From: Bloomer, David <David.Bloomer@lancashire.gov.uk>
Sent: 16 November 2018 14:50
To: Stephen Kilmartin
Cc: LHS Customer Service; planning
Subject: app3/2018/0914 Lawsonsteads Whalley, Phase 2

In 2013 outline planning permission was granted for a residential development of 260 units (3/2013/0137). The site is located on the outskirts of Whalley and sandwiched between Clitheroe Road and the A671 Whalley Easterly Bypass. The proposal was to be completed in 2 phases with the first phase comprising of 54 units with access taken from Clitheroe Road .Work has progressed on Phase 1 and this element of the site would appear to be substantially complete. Phase 2 of the development whilst linking into the estate roads constructed in Phase 1 was also required to provide a signalised access onto The Whalley Bypass prior to work commencing on site. All construction access to phase 2 was to be taken from the new Whalley Bypass junction. This will remain a highway requirement with no vehicular or pedestrian access being taken from the Phase 1 construction (Springwood Drive, Fountain Way).

INFORMATION				
Scale @ A1	Date Created	Drawn	Checked	
1:1000	28/09/18	KM	PM	
Project Number	Originator	Discipline	Drawing Number	Revision
1040-01	CIVIC	TR	0001	P04

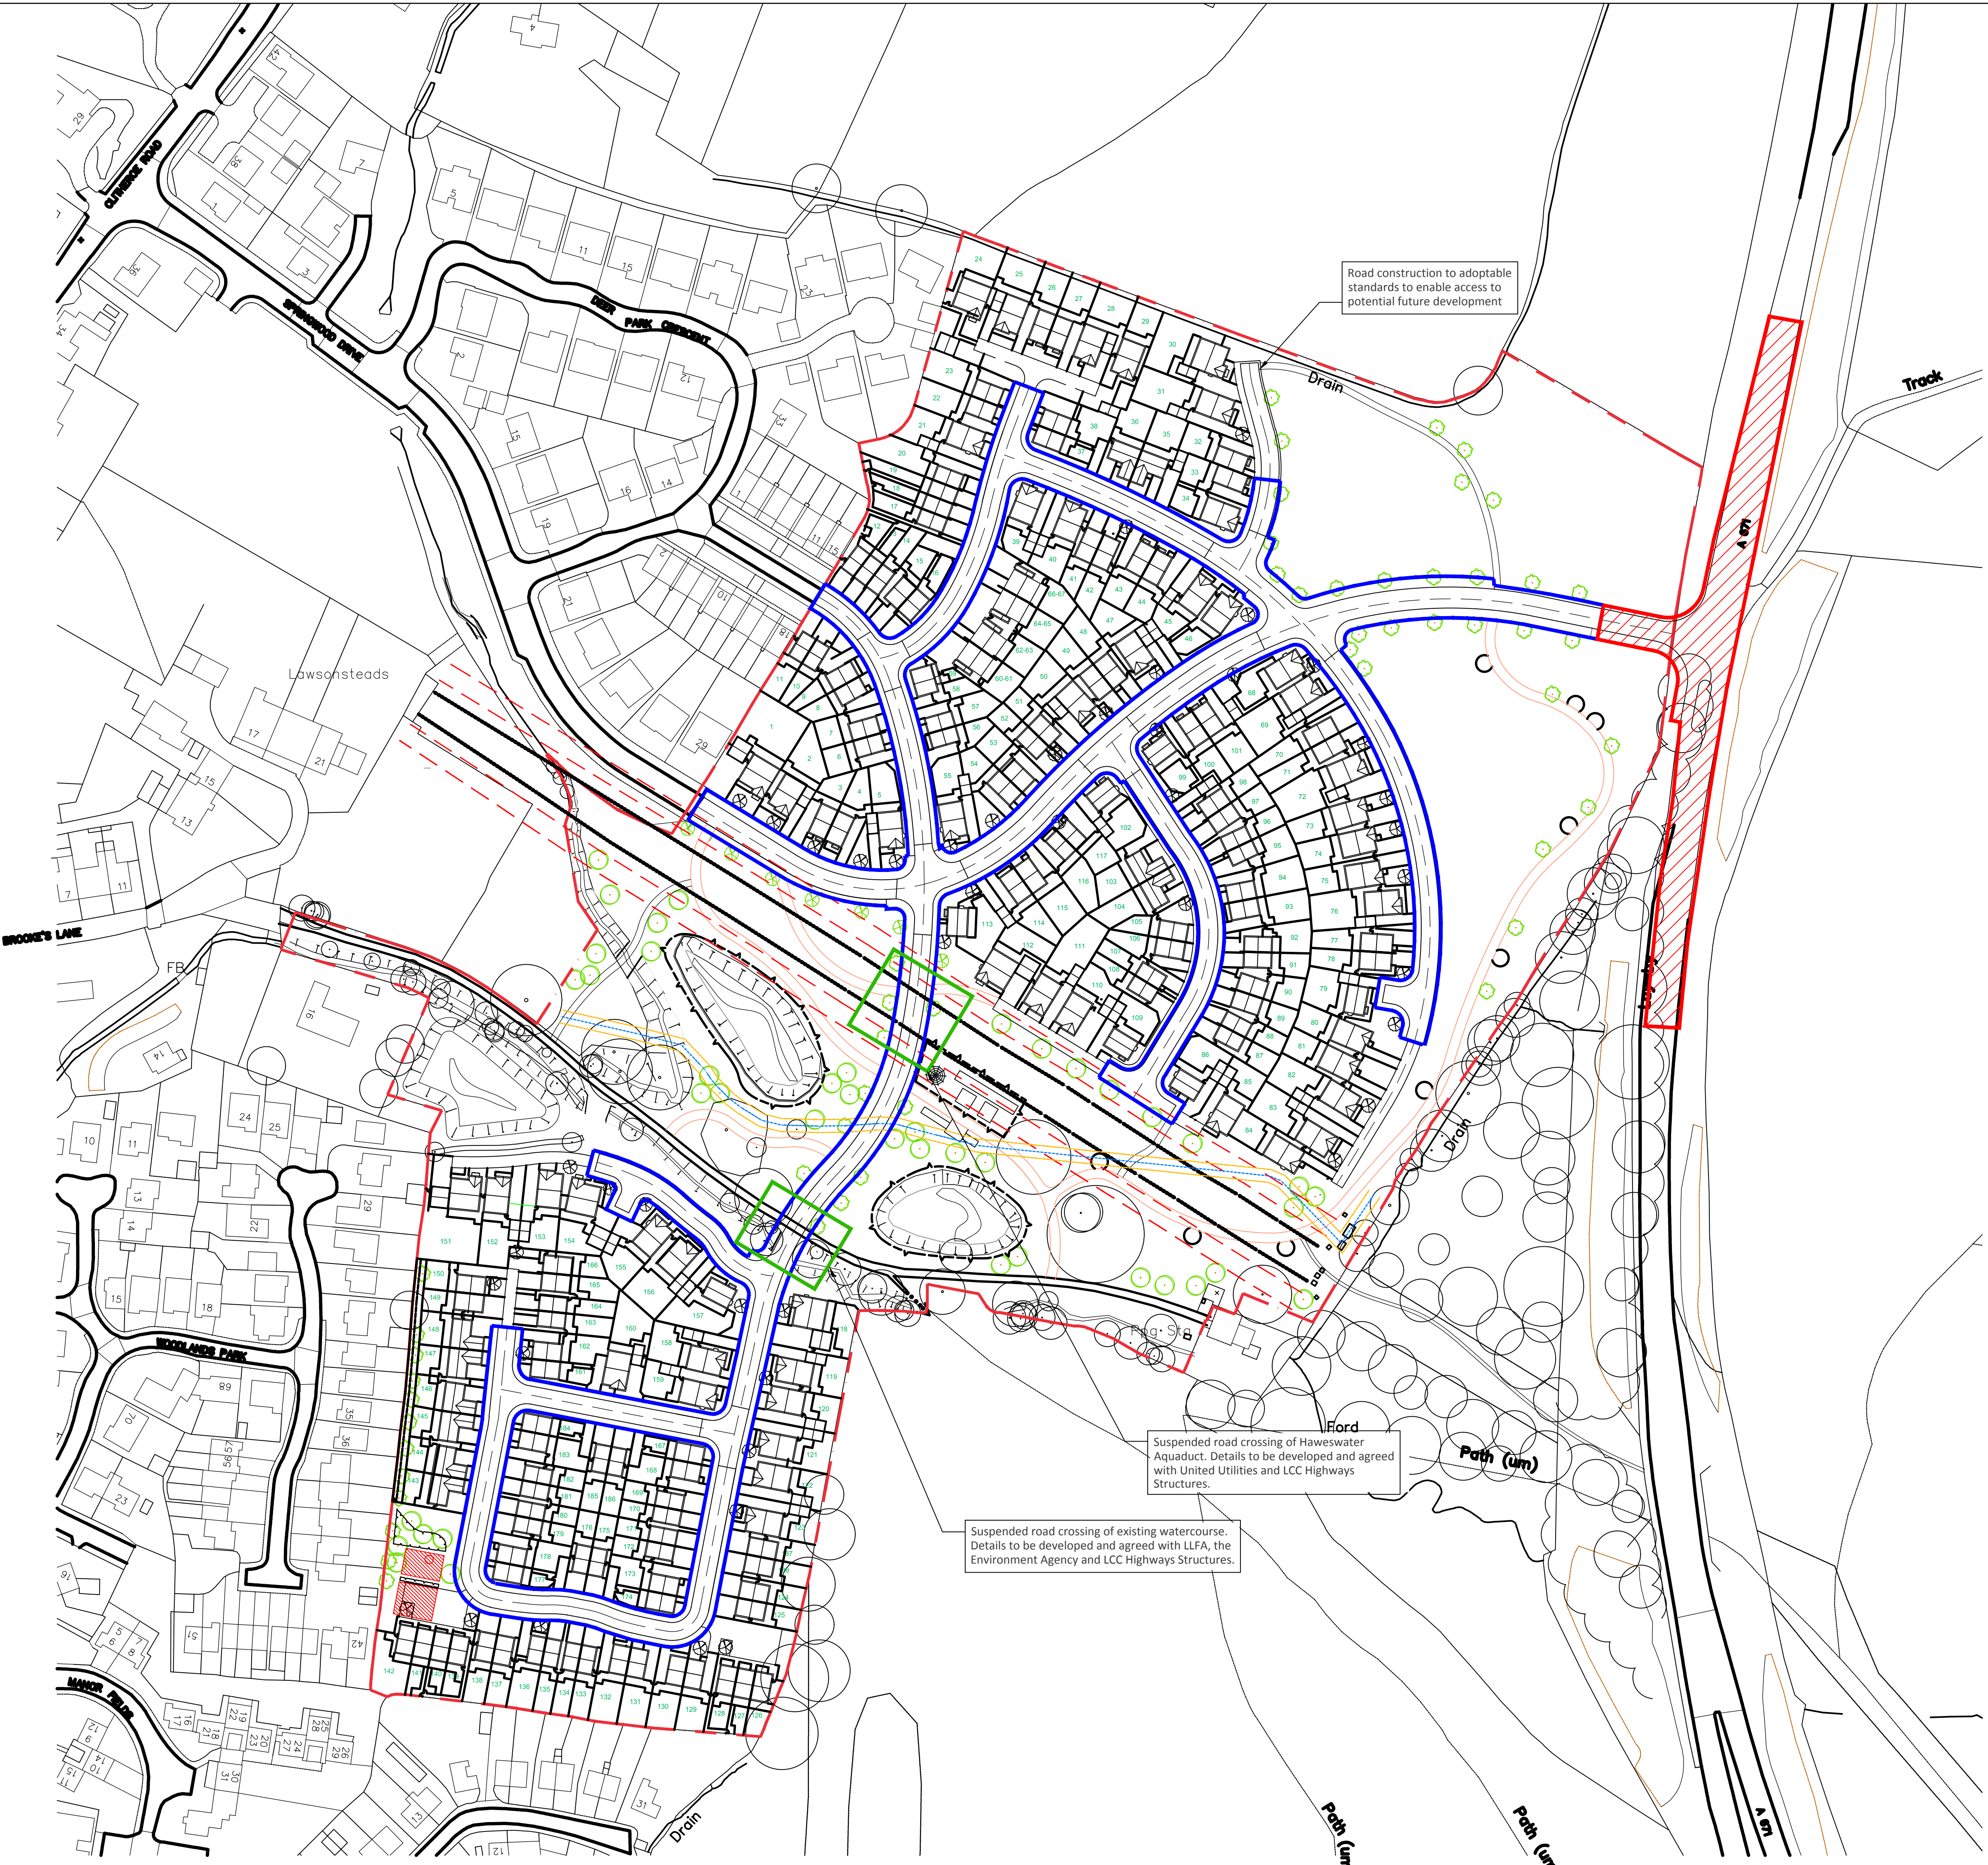
1 the proposed junction tables will need to be reviewed , whilst there is no objection to their location , a number of those proposed would need extending. This would be a detailed design consideration and dealt with as part of the S38 agreement process.

2 A turning head will be required for the cul-de-sac fronting units 30 – 34

3 A 2m footway will be required along the westerly side of the road to the front of units 102 – 109

4 What is the purpose of the layby area to the rear of unit 159?

5 The applicant will need to demonstrate that a vehicle, such as a refuse collection vehicle, can safely access all areas of the site with particular attention to cul-de-sacs and the area to the south west of the site.
